I AM WRITING TO YOU REGARDING THE PROPOSED PROPERTY ON LAND NORTH OF 13 HAZEL AVENUE WITHERNSSEA.

PROJECT DETAILS  
ERECTION OF A DWELLING  
**PLANS AS PROPOSED**

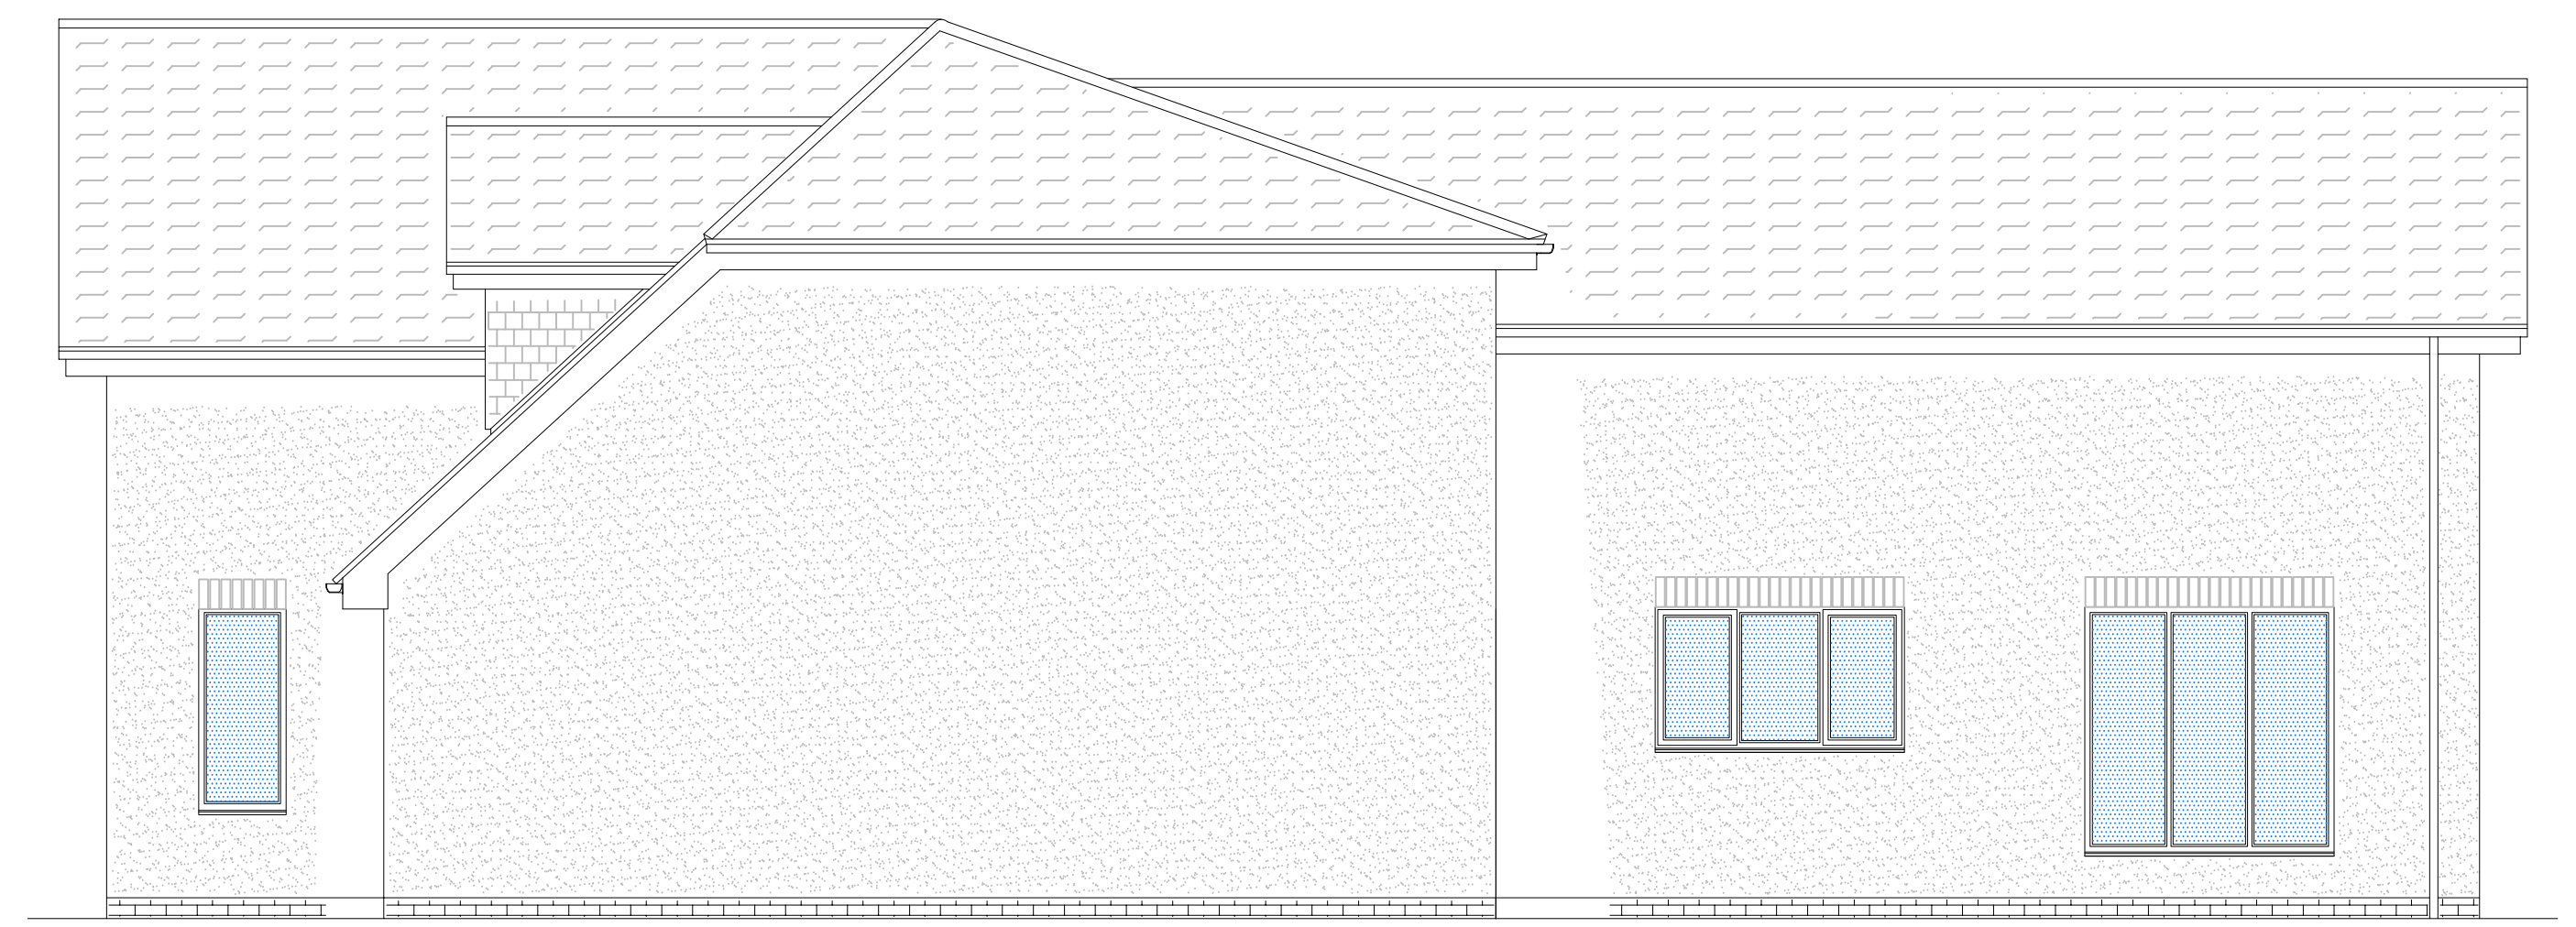
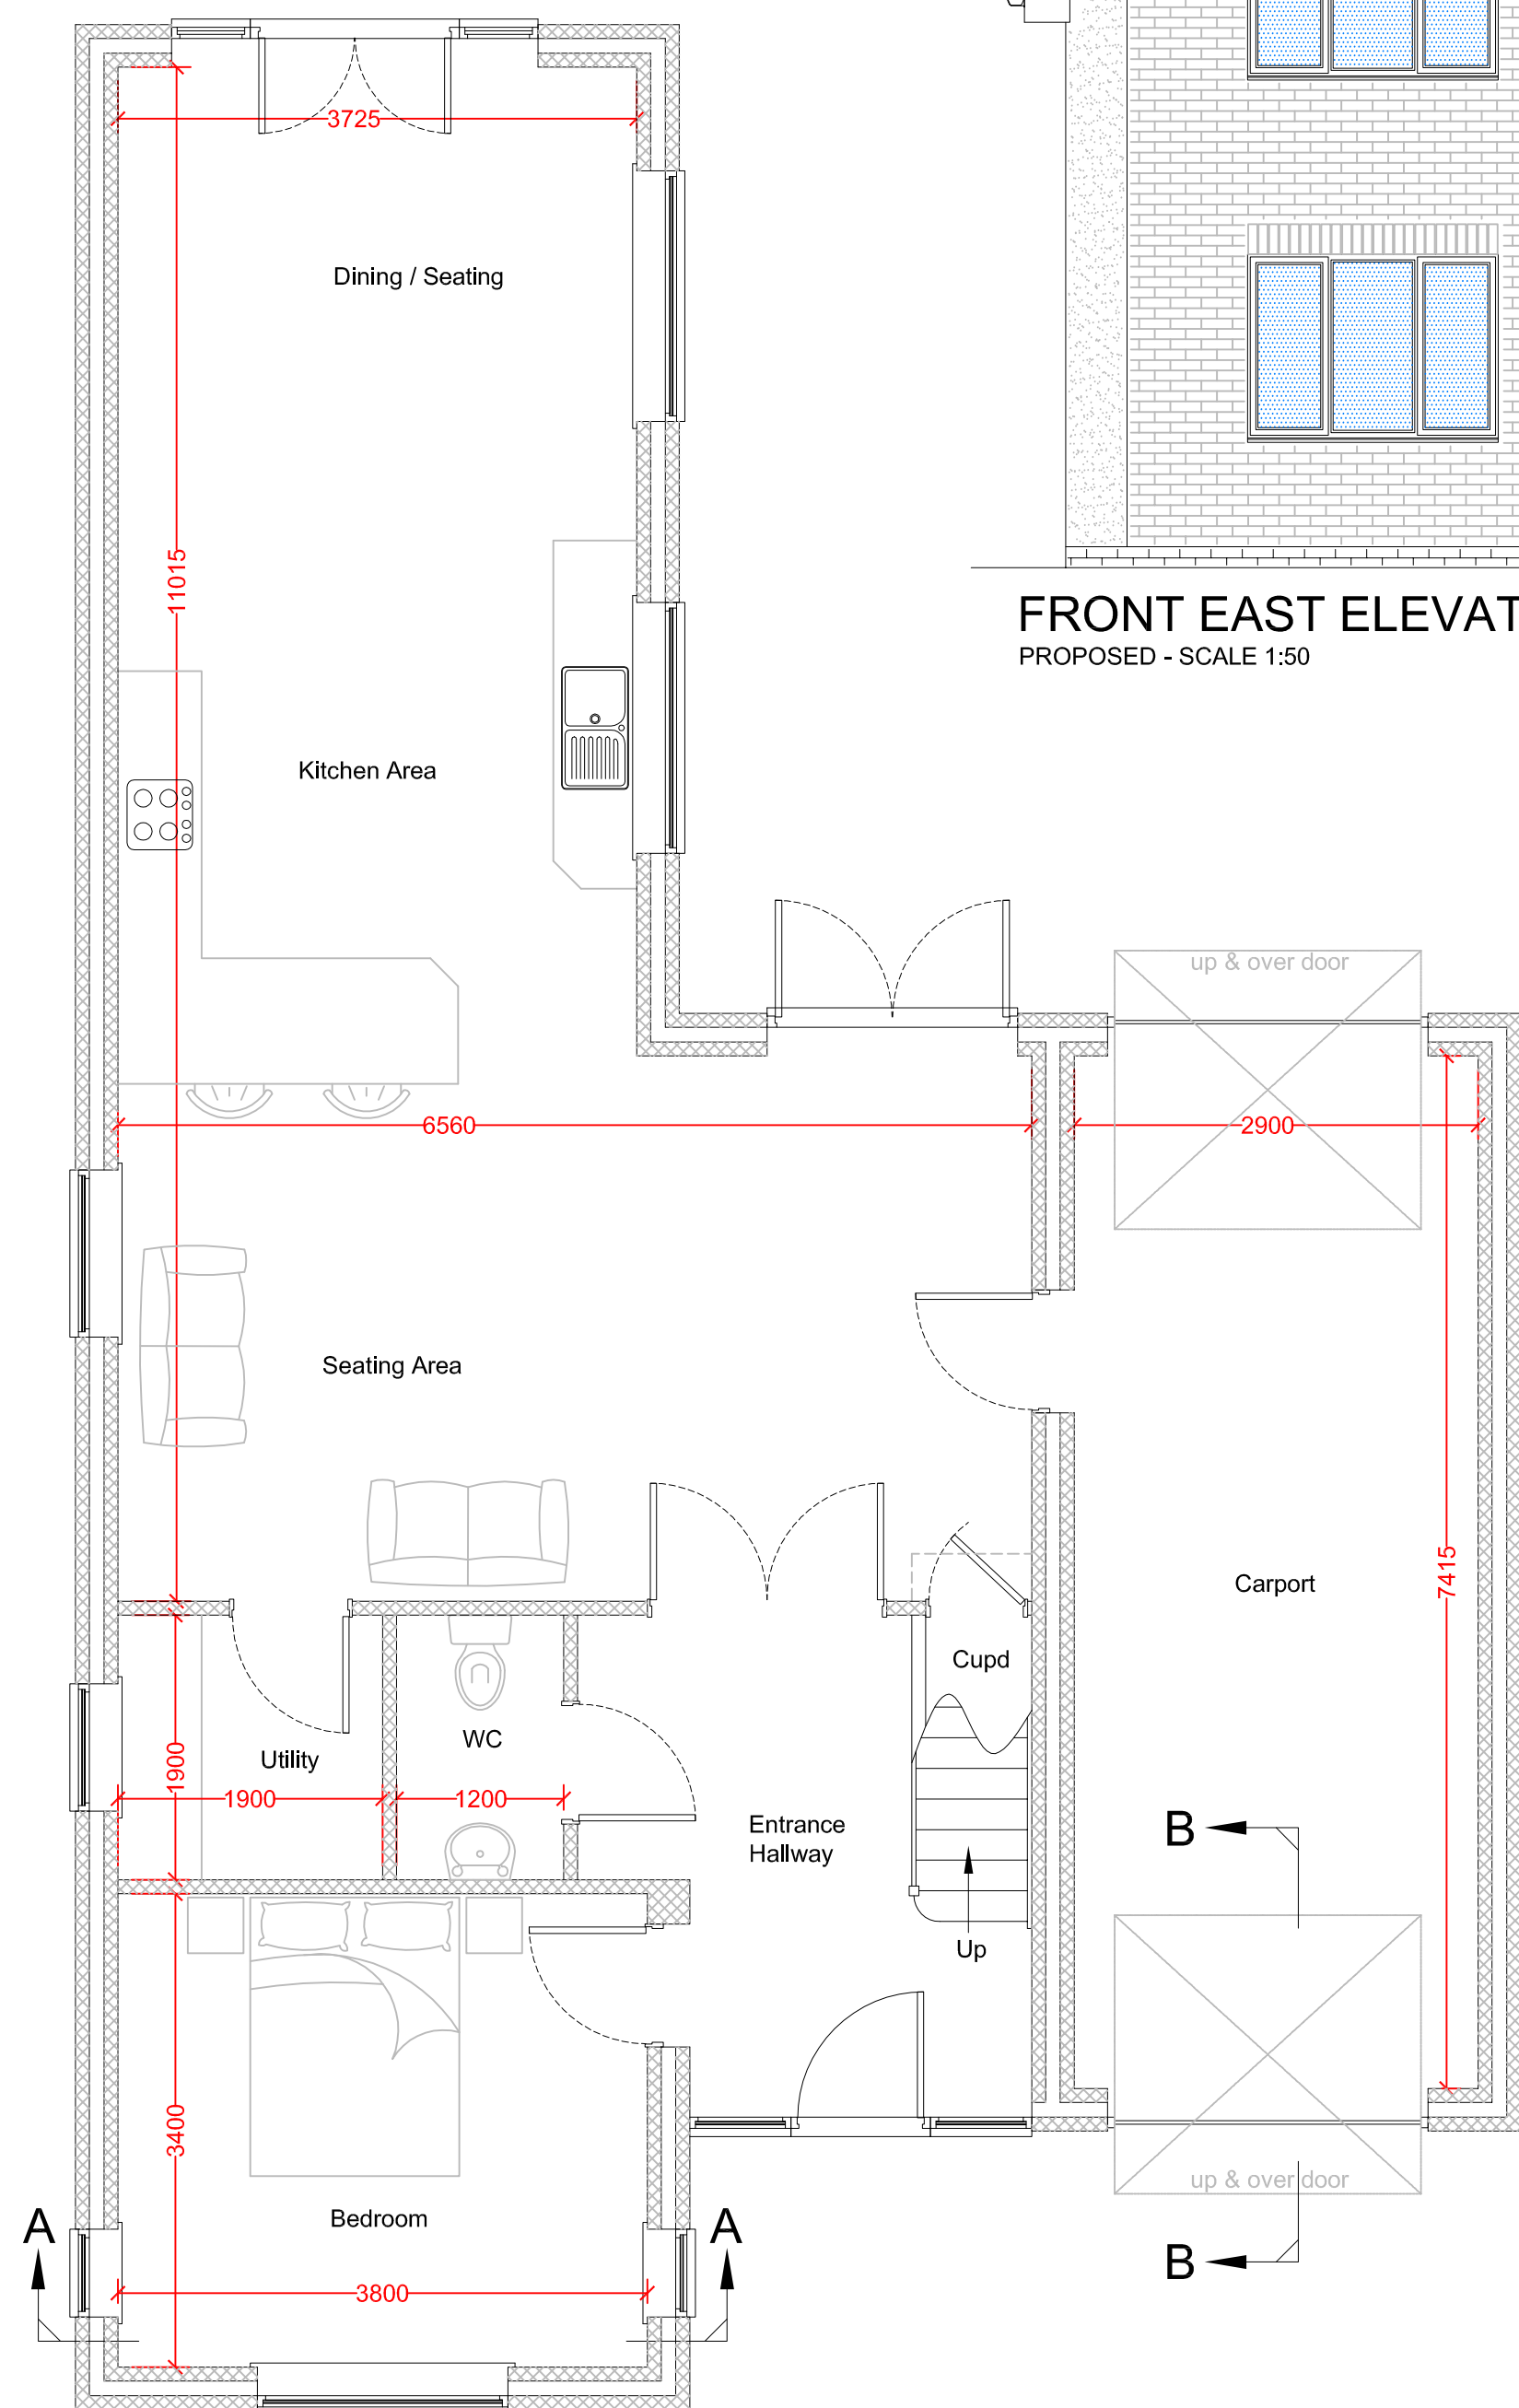
THE HEIGHT OF THE PROPOSED PROPERTY IS CERTAINLY GOING TO AFFECT MY NEIGHBOURS AT N⁰S 13 AND 15. NUMBER 13 ARE GOING TO HAVE THEIR PRIVACY COMPROMISED AS THERE ARE 2 BEDROOM WINDOWS OVERLOOKING THEIR FRONT DOOR AND GARDEN AND NUMBER 15 ARE GOING TO LOSE AN AWFUL LOT OF SUNSHINE AT THE FRONT AND BACK GARDEN. THIS HUGE 'GARDEN STORE' IS GOING TO OVER SHADOW THE BOTTOM OF THEIR GARDEN TOO.
